**STATEMENT OF ENVIRONMENTAL EFFECTS: SECTION 75W APPLICATION TO MAJOR
PROJECT MP NO.08_0257 STAGE 1 (BUILDINGS 4 & 5) – 61 MOBBS LANE, EPPING**

Pursuant to Section 75W (1) (a) of the Environmental Planning and Assessment Act 1979, a 'modification of approval' is sought to vary Condition No. A2 pertaining to Major Project MP No. 08_0257 Stage 1 (Buildings 4 & 5) as approved on the 15 September 2010. The modification is to amend architectural plans to accommodate minor design changes to the approved architectural plans arising from design and construction compliance.

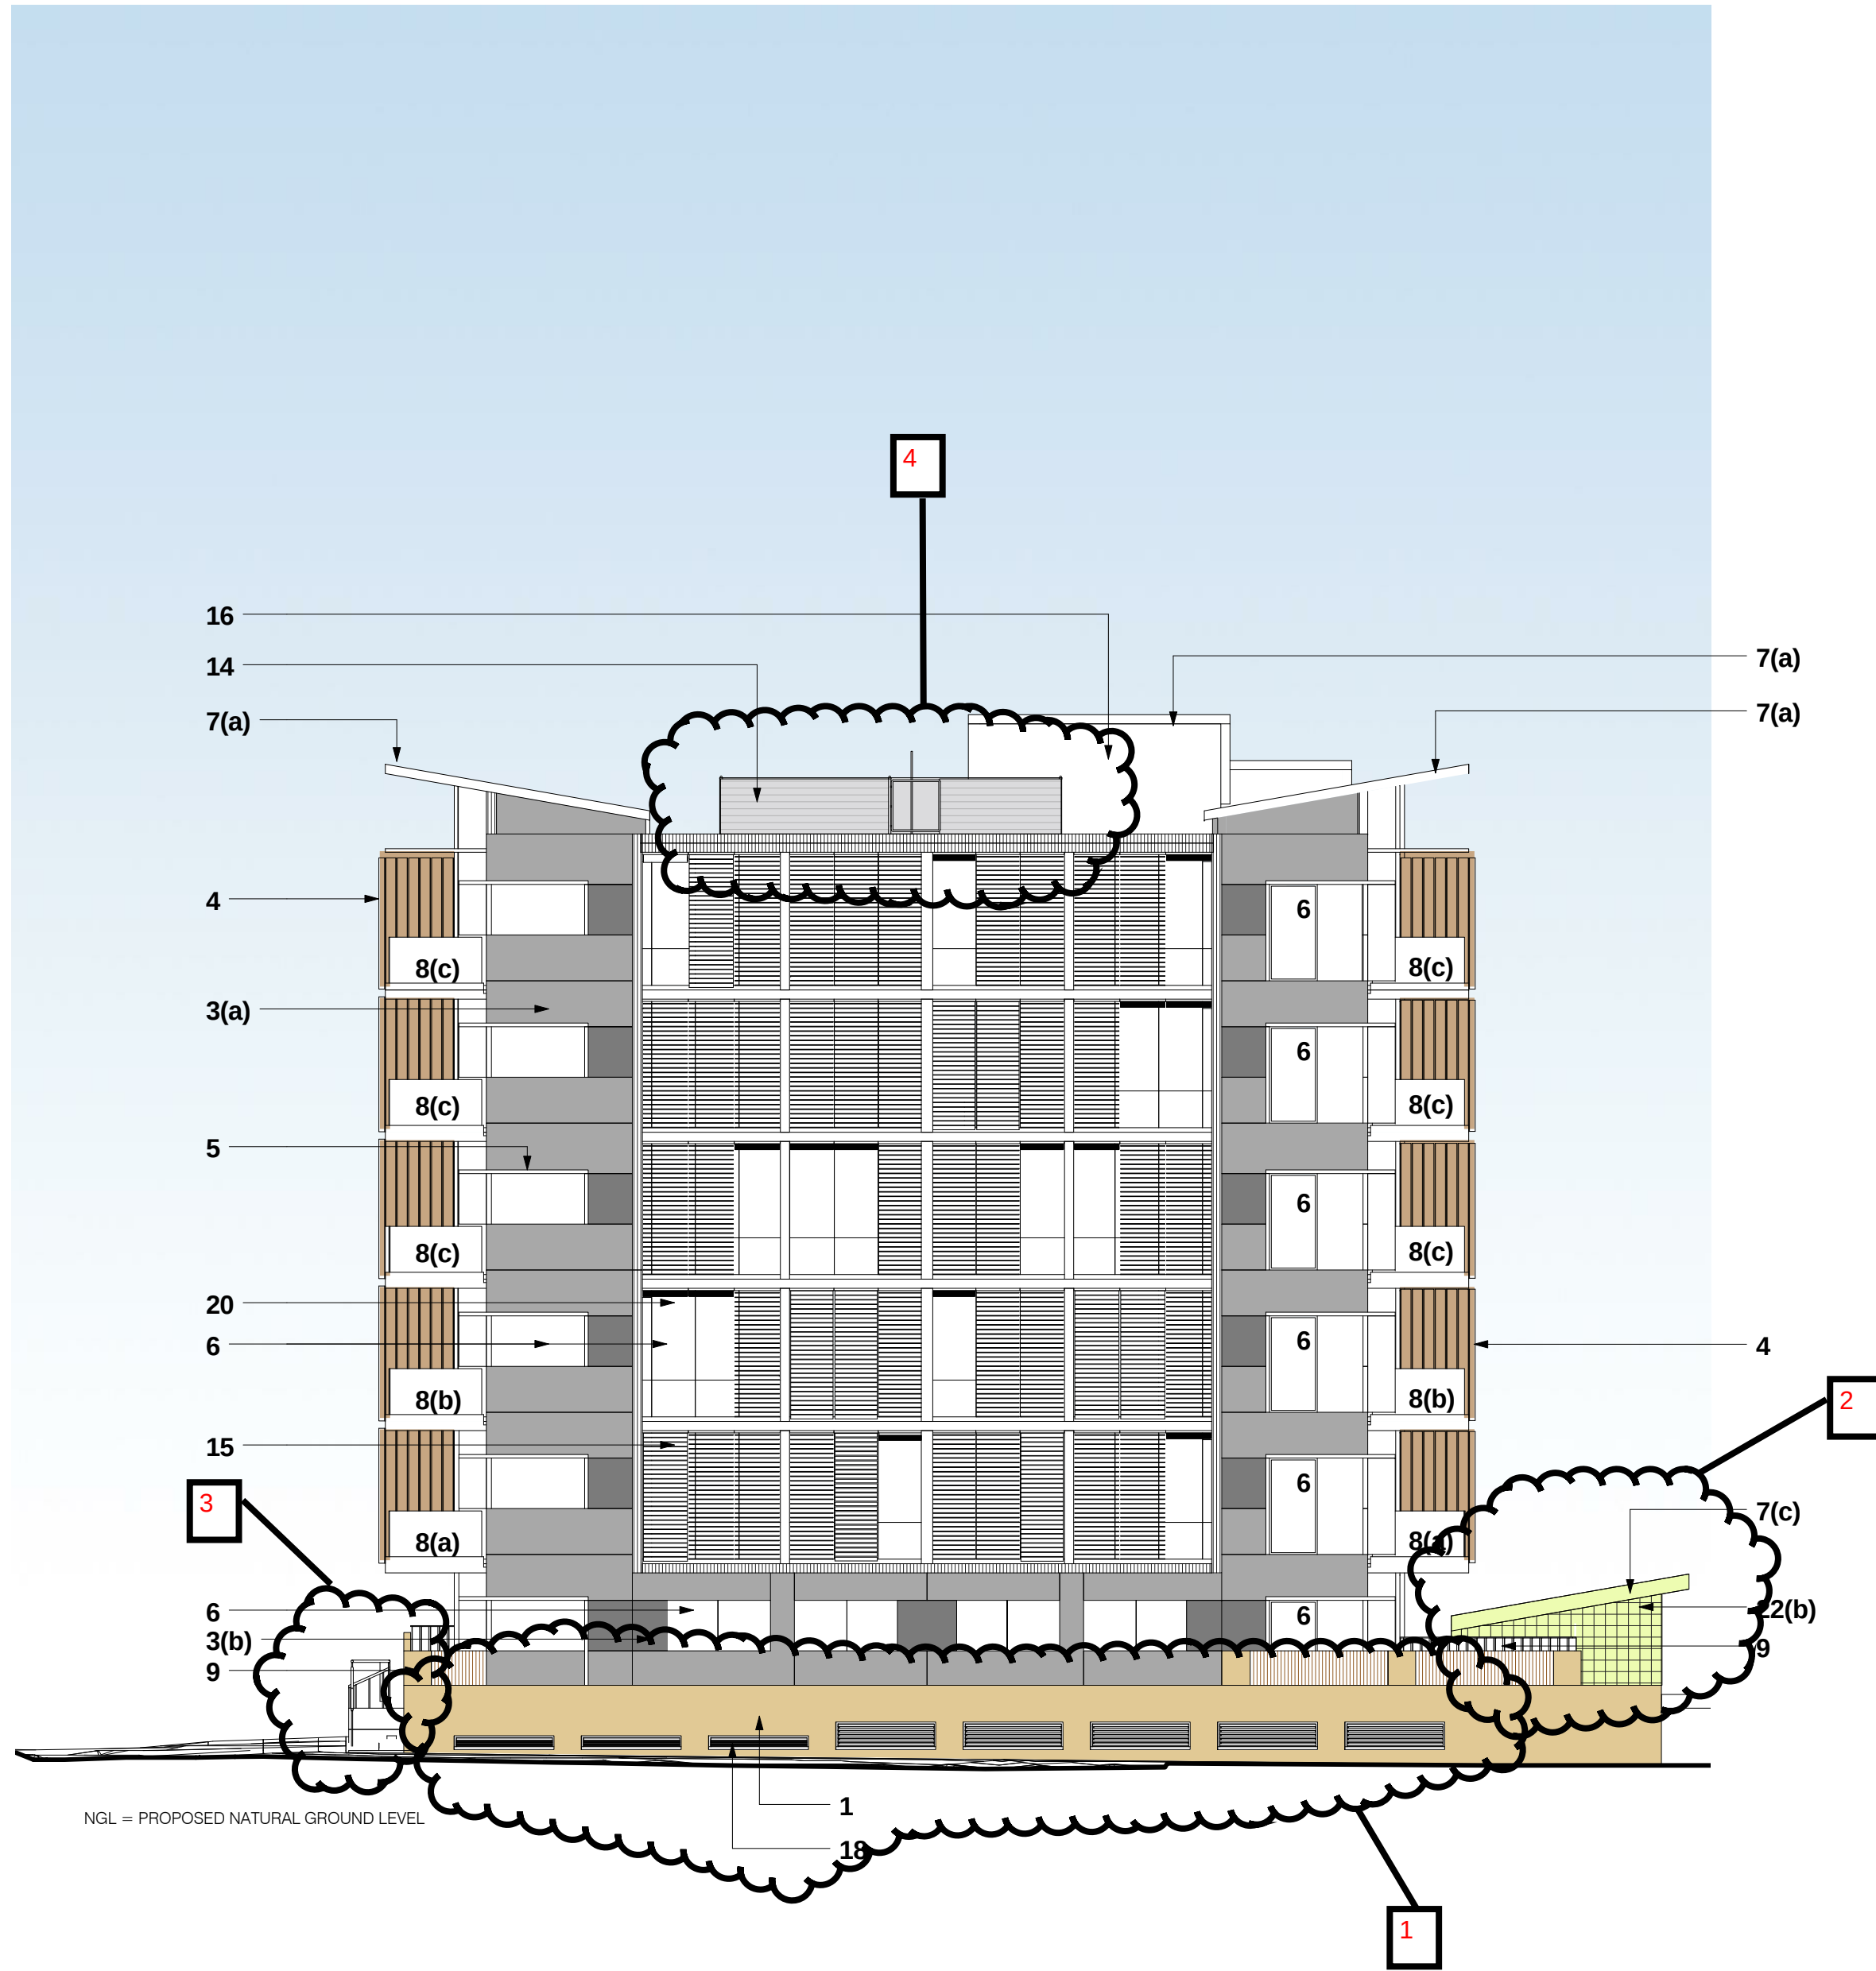
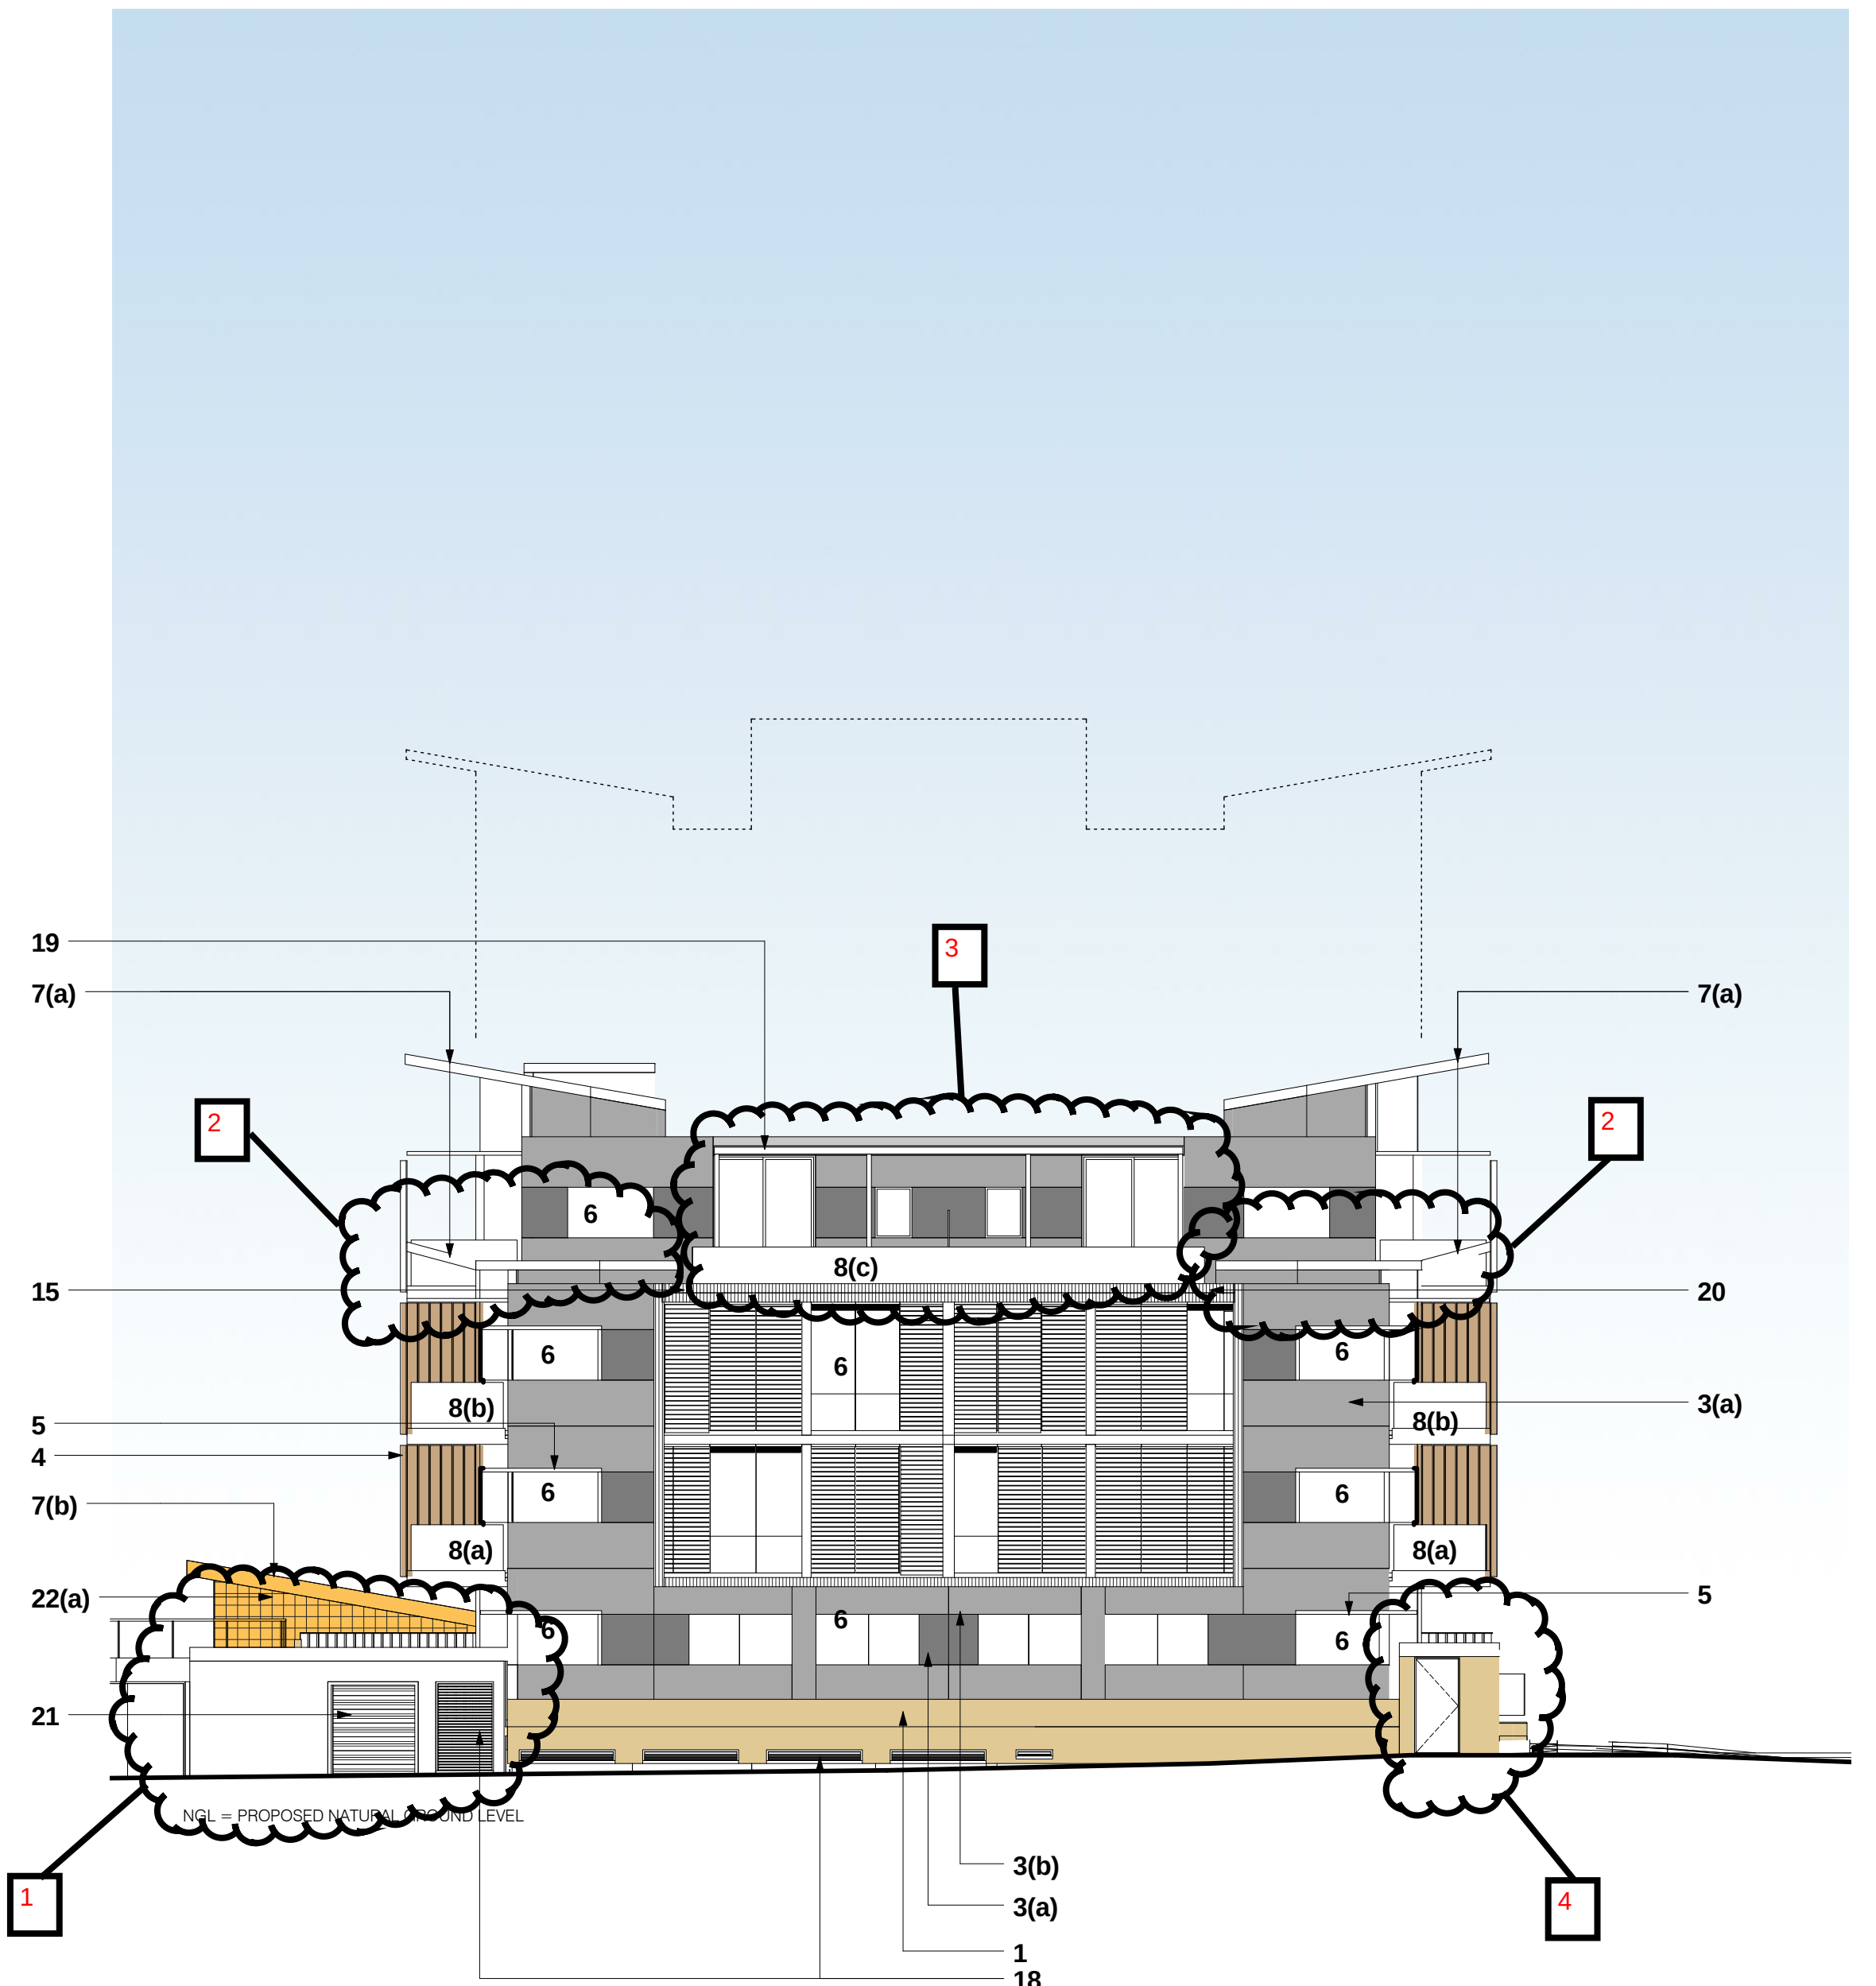
1. Amendments to basement level
2. Roof line details – ground floor
3. Change to stair access
4. Roof line details – central area

1. Amendments to garbage storage and substation area
2. Change to roof structures
3. Additional roof balustrades
4. New entrance
5. Stair access
